ADDENDUM

Job Title
34 POTTER STREET
NORTHWOOD
MIDD

Drawing Title
PROPOSED OUTBUILDING
AND LANDSCAPING
DETAILS

Drg No. 3936 / 02 Rev. KB

View from rear driveway gate
(side elevation) showing new mast position.

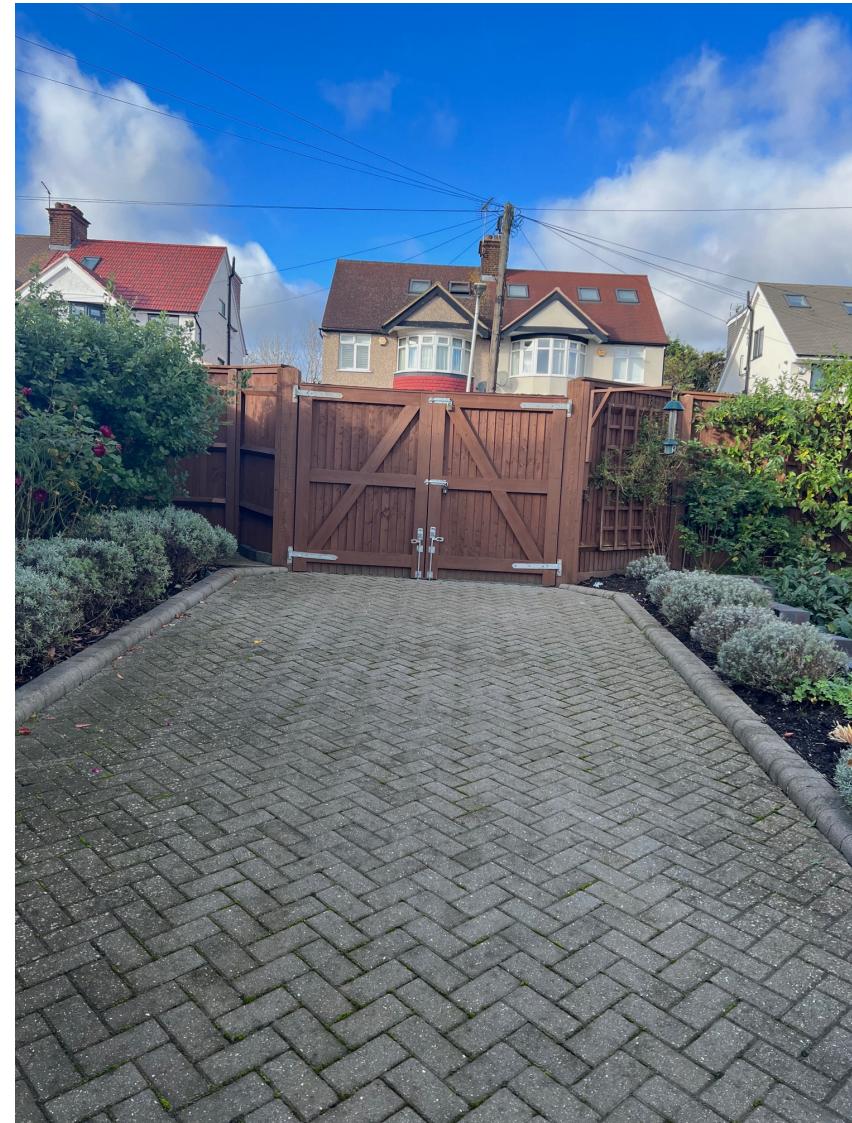
1. MAST HEIGHT = 10M
 2. MAST NOW SHOWN ON FRONT AND SIDE ELEVATIONS.
 3. MAST SUPPORT STAND-OFF BRACKETS = 300MM TO WALL.
 4. MAST EXTERNAL DIMENSIONS 80MM X 80MM X 10M IN GALVANIZED STEEL.
- NB: DRAWING UPDATED FOR FRONT AND SIDE ELEVATIONS ONLY.
5. MAST WILL SUPPORT ANTENNA WITH A ROTARY WASHING LINE PROFILE.
